**Fountain Tracking Number # SP-26-006**

**Kroger Spoke – Site Development Plan | 702 Bandle Drive, Fountain, CO 80817**

**Please see below for responses to the plan review comments provided by your department. We have provided an itemized list of the comments with responses below it. Please refer to the attached drawings with revision clouds in response to the comments.**

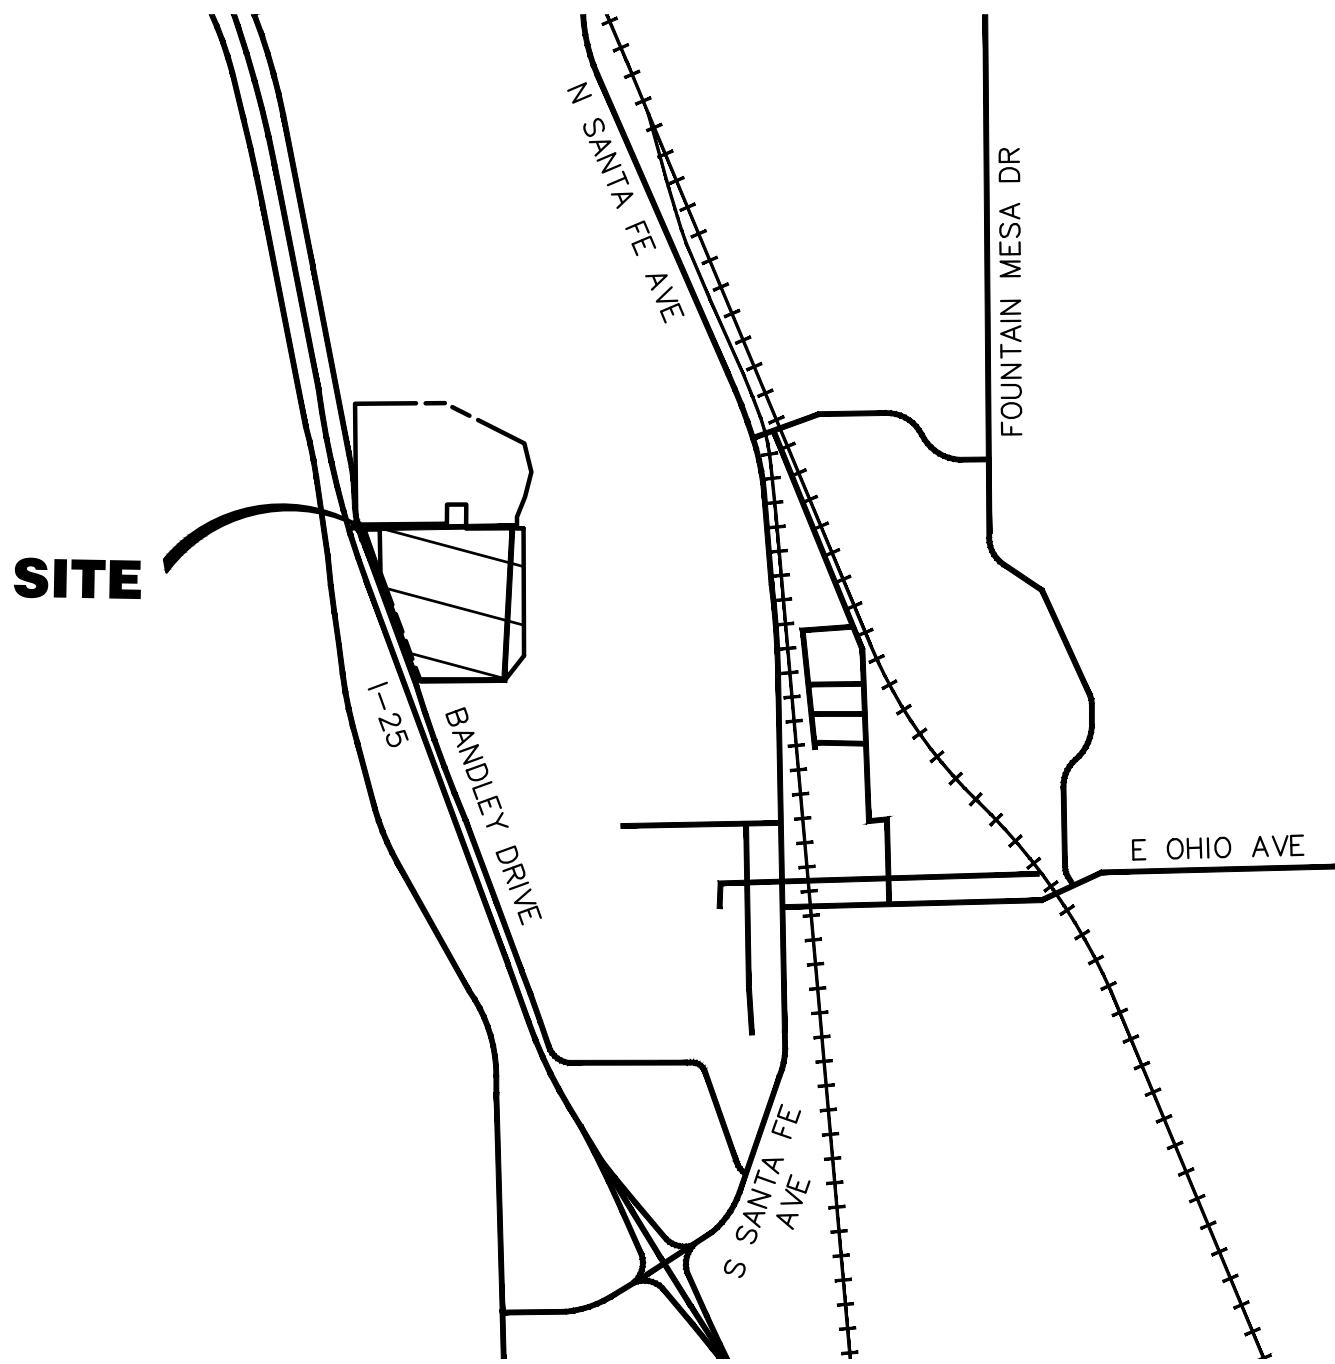
**Need cover sheet details of land uses size of building setbacks impervious area, need a clear site plan with setbacks to the building.**

**Response:** Site data table is on sheet C-201 I have added to cover sheet as well. This has impervious area. Building SF has been added to sheet C-201. Setbacks have been added to sheet C-100.

CITY OF FOUNTAIN WATER NOTES

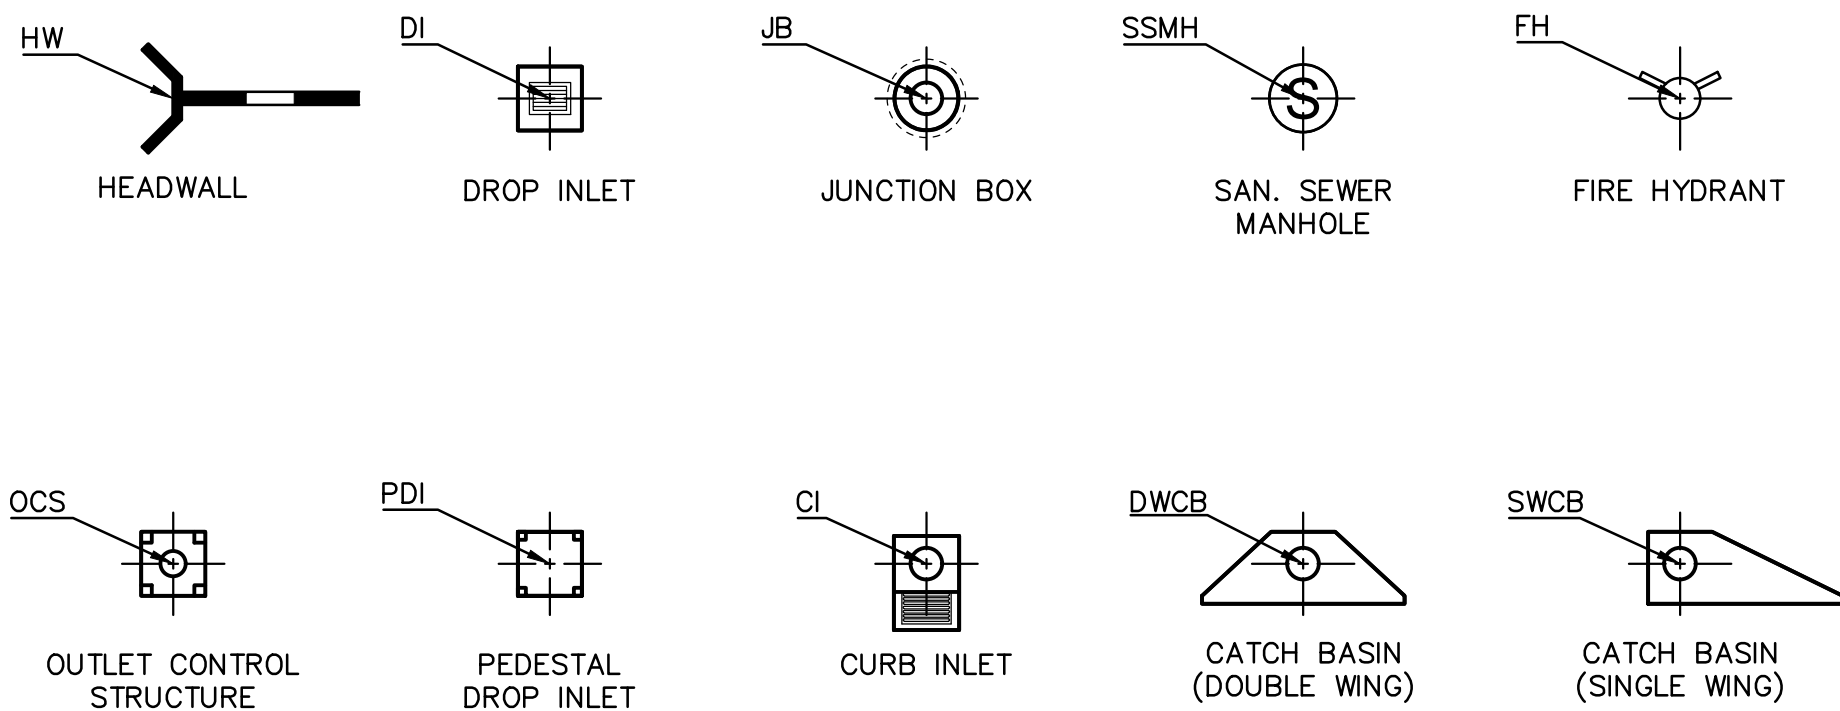
49. **Please add Water Notes to the plans:**
1. **All pipes, service lines and appurtenant installations shall be installed with 6 Ga. Coated copper tracer wire affixed every 3 feet.**

2. **All pipes and service lines should be installed with a minimum cover of 4' and maximum of 5'.**
  3. **All Gate Valves and Fire Hydrants shall open to the Left.**

4. **All public water service lines shall be HDPE DR-7 200 PSI minimum, IPS size, utilizing compression fittings with steel stiffeners.**
  5. **Water service Corporation Stops and Curb Stops shall be manufactured by Ford Meter Box Co.**

6. **Service line connections to PVC mains shall utilize Stainless Steel band tapping saddles manufactured by Ford or Romac.**
  7. **All PVC water mains shall be AWWA C900 DR-14.**

8. **All new Fire Hydrants are preferred to be AVK Series 2780 'nostalgic' style dry barrel.**
  9. **All pipe joints on fire hydrant laterals and private fire sprinkler lines shall utilize MJ bell restraints.**

10. **All pipe fittings shall be made of ductile iron complying with AWWA C153 and shall be affixed to a magnesium anode and be wrapped in polyethylene sheeting.**

11. **All water mains and public portions of water service lines shall be bedded with select material from 6" to 12" above the pipe in accordance with Class C bedding.**

12. **When crossing sanitary or storm sewer facilities, all potable water facilities shall cross above the conflicting utility with 18" of vertical clearance from OD to OD. When this is not feasible, or differing conditions are encountered in the field, the Water Inspector shall be informed and additional protective and/or containment measures will be required at the Owner's expense.**

13. **The Contractor is responsible for conducting, and supplying all equipment for, the Bacteriological and Pressure Acceptance testing of all new water mains, to be performed under the supervision of the City's Water Inspector. Pressure testing of Fire Sprinkler Lines shall be coordinated with the City of Fountain Fire Marshal.**

**Response:** Notes have been added to sheet G-001 under "City of Fountain Water Notes"

C-201B

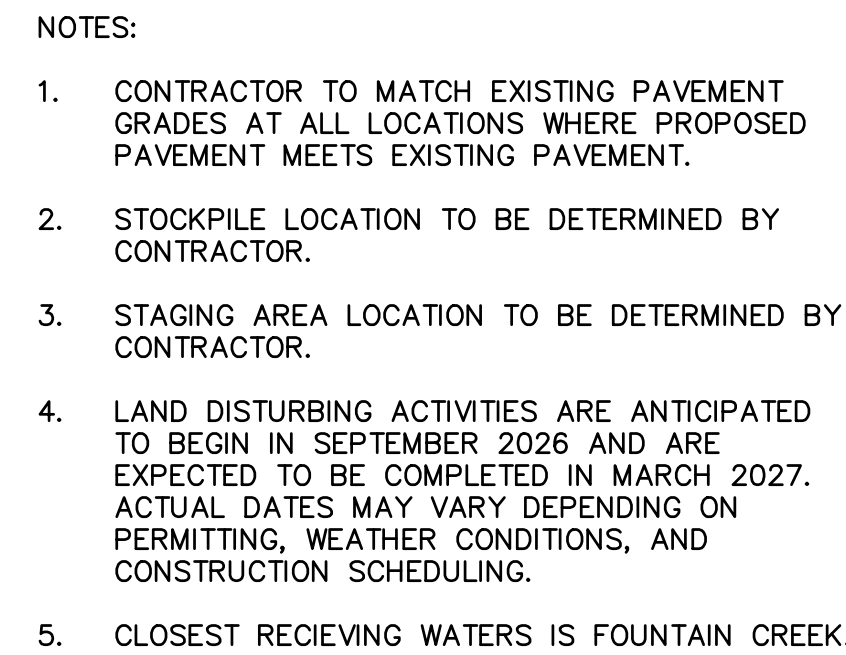
**Work out requirements for arch regs on Dockzilla, maybe admin relief.**

**Response:** The proposed Architectural solution was discussed and agreed upon during preliminary discussion with the City of Fountain. The proposed buildings were designed to integrate seamlessly with the established character of the Fountain Business Park.

To ensure the new structures complement the existing industrial context, the pre-manufactured office & Dockzilla units will have a customize Façade. This includes the installation of high-quality architectural skirting to create a permanent, finished appearance and a color palette selected to match the primary building within the park. Additionally, entry canopies will be added to provide covered access and improvement of the appearance of the office building. Both buildings sets are currently under permitting at state level with the housing department (DOH) and will subsequently be reviewed by the Pikes Peak Regional Building Department (PPRBD)

C-203

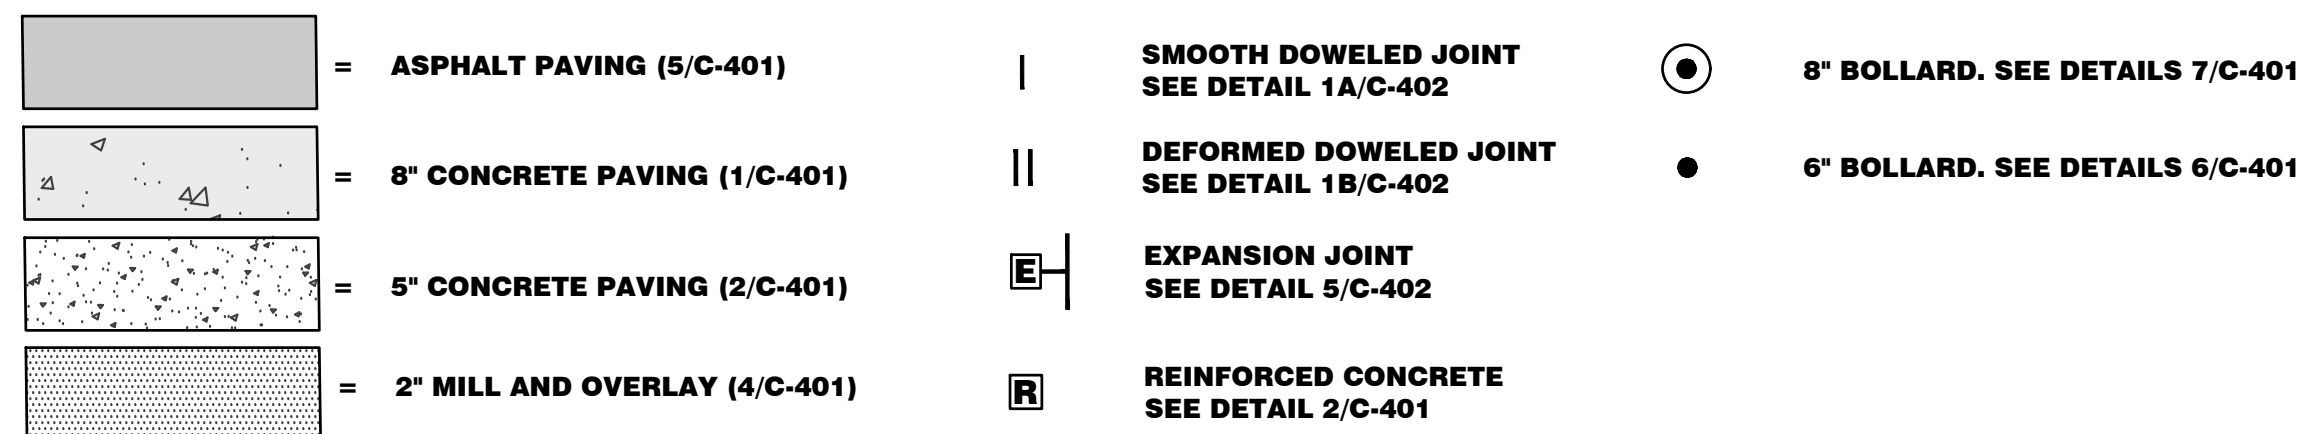
55. **Planning B: (Page 15) C-203 Utility Plan**  
**Consider lining the approach to the Dockzilla with trees in lieu of arch requirements**

- 38. COF Water B: (Page 15) C-203 Utility Plan**  
Add pipe description from tap to curb stop valve: SDR7 HDPE.

- 39. COF Water B: (Page 15) C-203 Utility Plan**  
Add pipe description from curb stop valve to 3/4x1 reducer.

- 40. Engineer B: (Page 15) C-203 Utility Plan**  
Add pipe description.op

- 41. Planning B: (Page 15) C-203 Utility Plan**  
Remove "all" bends, does not require to use fittings on a 1" copper piping.

- 42. Planning B: (Page 15) C-203 Utility Plan**  
Remove

- 43. Planning B: (Page 15) C-203 Utility Plan**  
Add Curb Stop to the description, before VALVE.

- 44. Planning B: (Page 15) C-203 Utility Plan**  
Add Pit to the description after WATER METER.

- 45. Planning B: (Page 15) C-203 Utility Plan**  
Add description.

- 48. COF Water B: (Page 15) C-203 Utility Plan**

**CITY OF FOUNTAIN WATER UTILITY TECHNICAL PROJECTS REVIEW** The Project Documents that this endorsement is affixed to have been reviewed by the Water Utility staff

51. Callout B: (Page 15) C-203 Utility Plan  
Move 2-way clean-out to outside of building.

52. Text Box B: (Page 15) C-203 Utility Plan  
Add FSD signature block, see website.

**Response:** While architectural requirements were requested by the City of Fountain at the project's onset, using trees to line the approach in lieu of these standards was not part of those initial discussions.

Instead, the agreed-upon solution for the pre-manufactured office and the Cross-dock building (Dockzilla) were designed to have a customized Façade. The design features high-quality architectural skirting to create a permanent, finished appearance, paired with a color palette specifically selected to match the primary building within the industrial park. Additionally, entry canopies will be installed to provide covered access and enhance the overall appearance of the office building. The Dockzilla buildings are approved by the DOH and the Office building is currently undergoing permitting at state level with the housing department. Both will subsequently be reviewed by Pikes Peak Regional Building Department (PPRBD)

**Response:** Pipe Description Added.

**Response:** Pipe Description Added

**Response:** Pipe Description Added

**Response:** Bend callouts have been removed.

**Response:** Pipe bends have been removed.

**Response:** Curb Stop has been added to description as requested.

**Response:** Pit has been added to description

**Response:** Description is shown in the utility insert A, on Sheet C-203

**Response:** Statement added to sheet C-203

**Response:** 2-way clean out has been called out. This was always the intention but call out was left off.

**Response:** FSD Signature block has been added.
